An Coimisiún Pleanála,
64 Marlborough St,
Dublin 1,
D01 V902

27th August 2026

Re: An Coimisiún Pleanála Reference ACP-323860-25– Request for Further Information Response. 10 year planning permission for a 220kV AIS/ 220kV GIS substation OR a 110kV electricity substation, associated 220kV or 110kV underground grid connection and ancillary works located in the townlands of Ballyloo, Knockbower, Linkardstown, Kilballyhue, Graiguenspiddoge, Castletown, Moyle Big, Leagh or Ballybeg, Kellistown West & Kellistown East, County Carlow.

Elevation View
SCALE 1:50

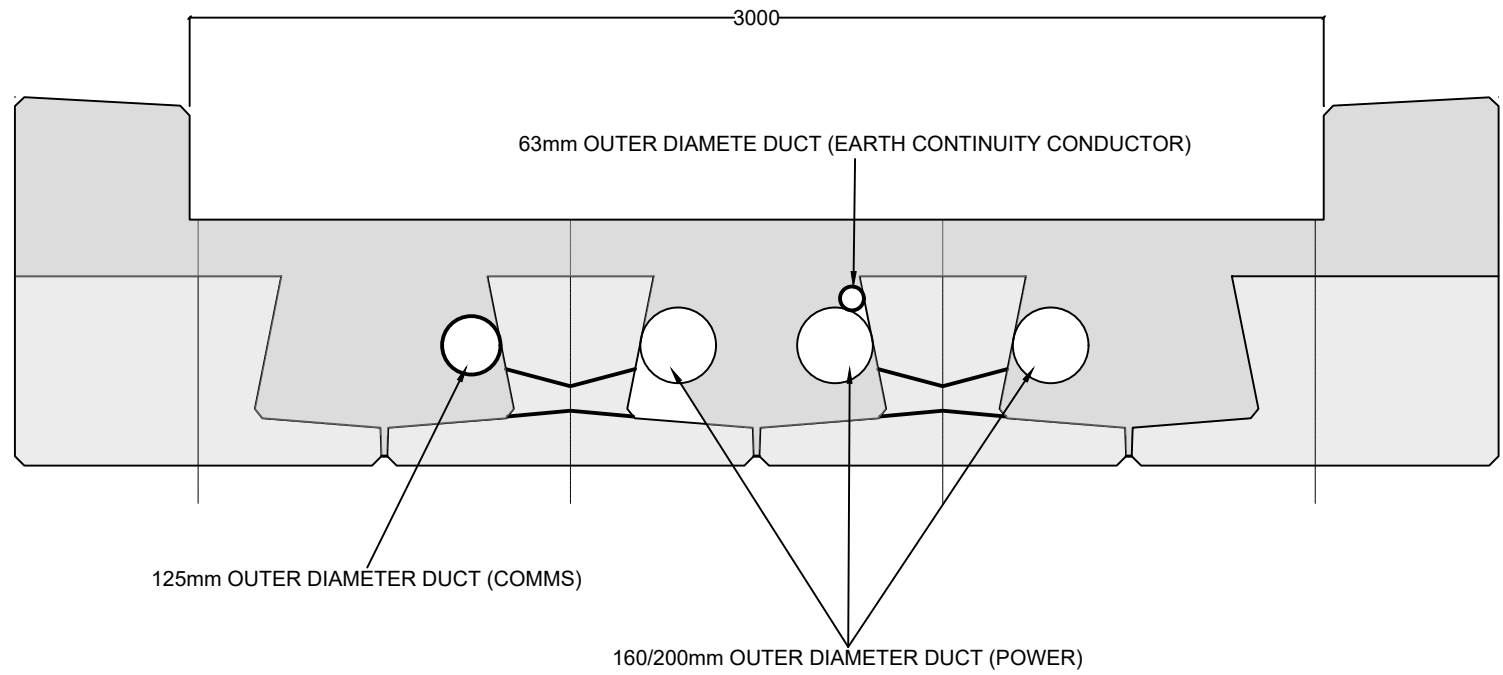
- (i) *While reference has been made in h) above to a dry deck bridge, and a drawing has been provided of a dry deck bridge at the proposed entrance to the proposed substation site, it is also noted that Figure 5.4 in the Site Access Report, and Appendix A to the Site Access Report, both which demonstrate the Swept Path Analysis of Entrance 1, includes a note that states 'New Roadside drainage to be carried in new 450mm Ø (diameter) concrete pipes surrounded in concrete during both the construction and operational phases'. In addition, sections 8.3 and 9.6 of the Site Access Report also refer to the installation of 450mm diameter pipes parallel to the site entrance and the use of soakpits. Please clarify these statements in the context of item h) above and in the context that other submitted documents state that no instream works are to be carried out as part of the proposed development, which would not be correct, if it is intended to install roadside drainage pipes in an existing roadside drainage ditch.*

The above drawing includes long-sections of the proposed dry deck crossing. It should be noted that two versions of the dry deck crossing are now proposed. One version is a temporary crossing for construction phase only. The full extent of this dry deck crossing is shown on the above drawing. This crossing is appropriately designed to facilitate construction phase traffic including the largest vehicles associated with the delivery of the proposed substation transformer. As set out in the Construction Method Statement, the construction method for installation of the deck involves assembling prefabricated structural elements without any in-drain works.

- Roadside drainage at the entrance will be carried in the proposed 450 diameter roadside pipe drain. The drainage pipe will be carried over the existing drain at the northern end of deck (and will not require any in-stream works). Any water captured in this drain will be directed to a soakaway and not the drain beneath the deck⁶.

The roadside drainage pipe referenced in the Site Access Report (RFI item 1(i)) is a proposed c. 450mm interceptor for surface water generated within the development, consistent with a standard planning condition against surface water discharging from the site to the public road. This is illustrated on the updated drawing 2025-09-10-03-D01_Proposed Construction Water Management – Entrance 1 Dry Deck Details prepared by CSEA Engineering Advisors. The drainage pipe will be carried over the existing drain at the northern end of deck (and will not require any in-stream works). Any water captured in this drain will be directed to the compound soakaway and not the drain beneath the deck.
